Engineers Comments Regarding Surface Water Drainage

Application Reference:	P/107/25/DOC	Reviewer Reference:	ADC/EXT4
Planning Officer:	Jessica Riches	Date of Review:	12/12/2025
Site Name:	Land West of Hook Lane Pagham PO21 3PB		
Application Description:	Approval of details reserved by condition imposed under P/149/23/S73 relating to condition 9 c) surface water drainage.		
Assessment Number:	3 of 3

Application Reference: P/107/25/DOC Site Name: Land West of Hook Lane Pagham PO21 3PB	Initial Issue Date: 12/12/2025 Issue Date: 12/12/2025 Reviewer Reference: ADC/EXT4
--	--

ST1
(CLOSEST LOCATION TO TREES)
SCALE 1:20

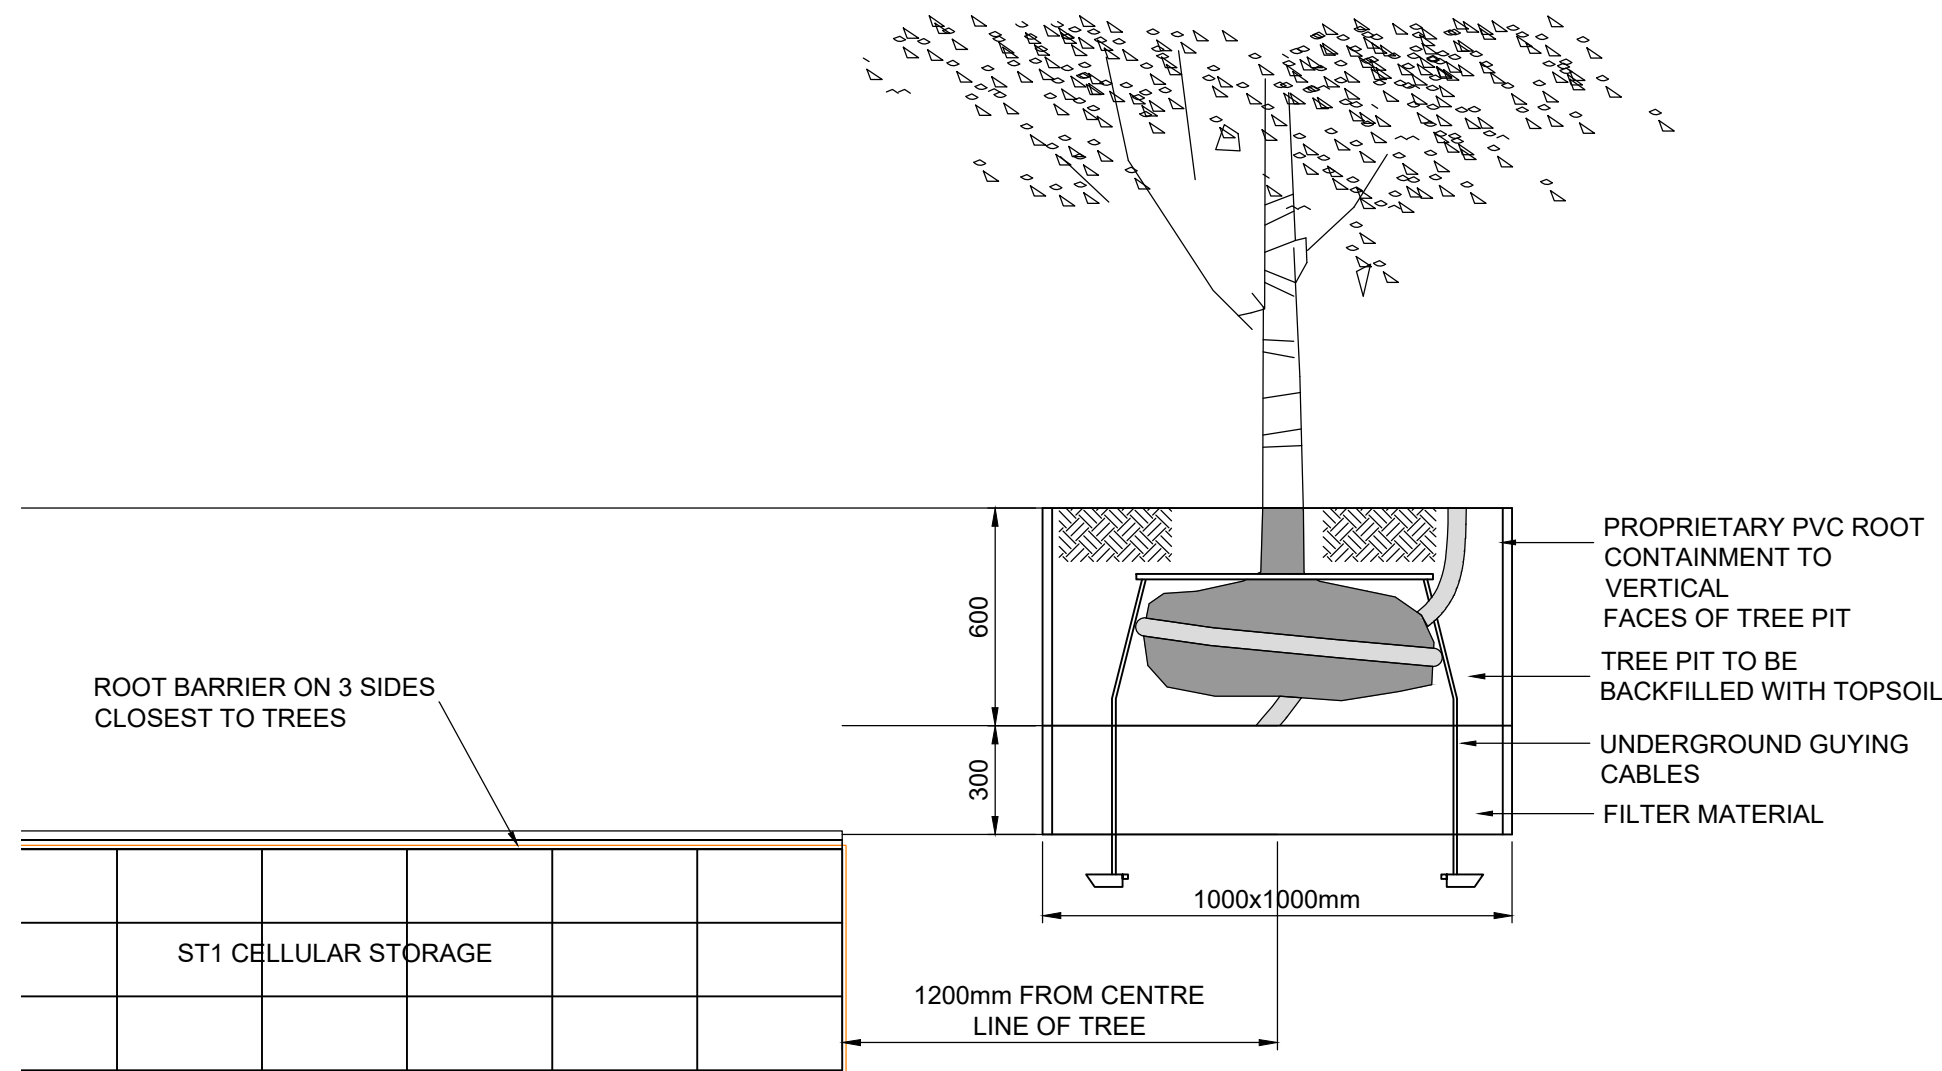
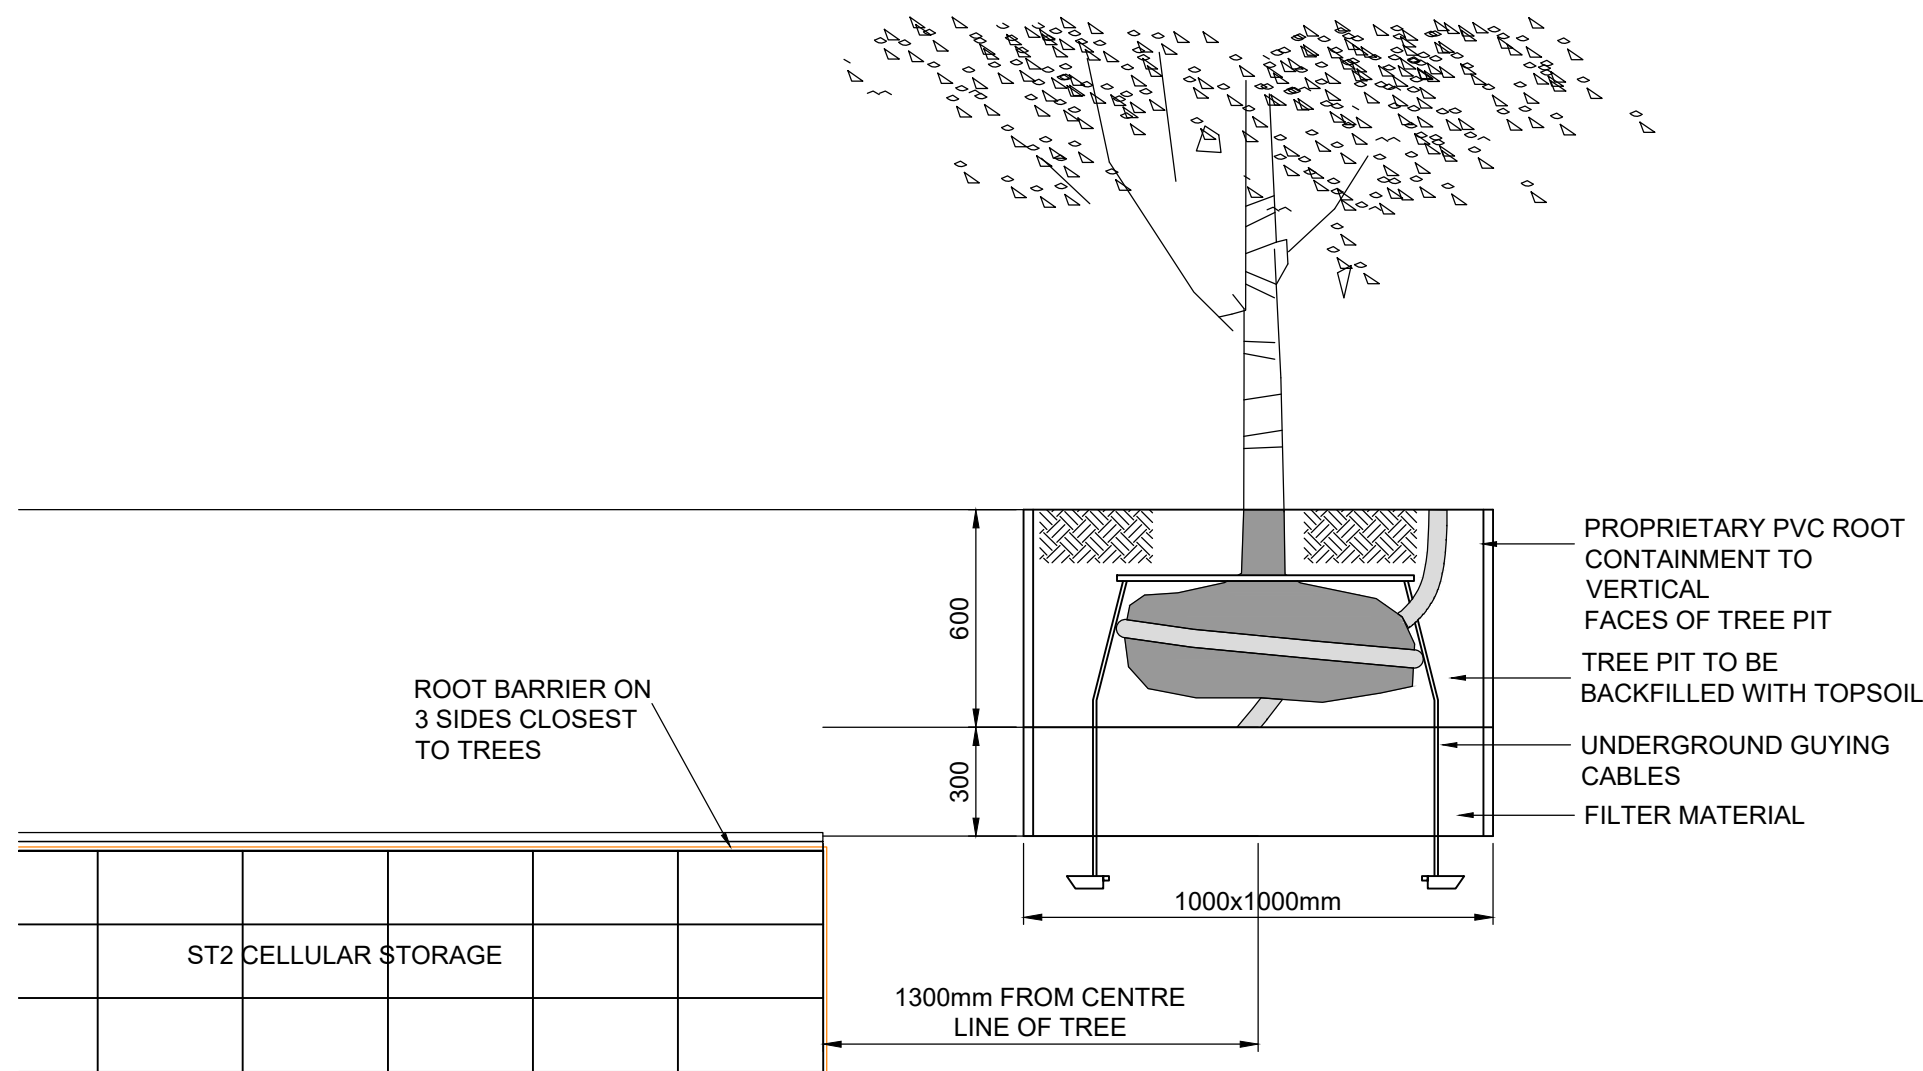
8	Detailed landscaping proposals are required to demonstrate that the landscaping and drainage proposals are coordinated. a) The indicative landscape proposal drawing shows a tree very close to tank ST1. Section A-A provided does not appear to represent this.  b) Provide information from the root barrier manufacturer and the tank manufacturer that the proposal is acceptable. c) Demonstrate that the tanks are structurally sufficient given the close proximity of the trees. d) Provide accurate cross sections showing that there is adequate space for the building foundations, foul	A. Rev C Calculations - Updated Drawings & Calculations. B. See Appendix G. C. See Appendix G. D. Updated Drawings & Calculations. See Appendix G. F. Updated Drawings & Calculations.	a. item now closed b. item now closed c. item now closed d. item now closed e. item now closed f. item now closed g. (New Item(there appears to be clashes on the proposed drainage runs and trees SW-IC03.01 to SW-MH-02.01 and SWIC-01.03 to SW-IC01.04	See revised drawings in Appendix F showing no clashes with trees.	Item now closed
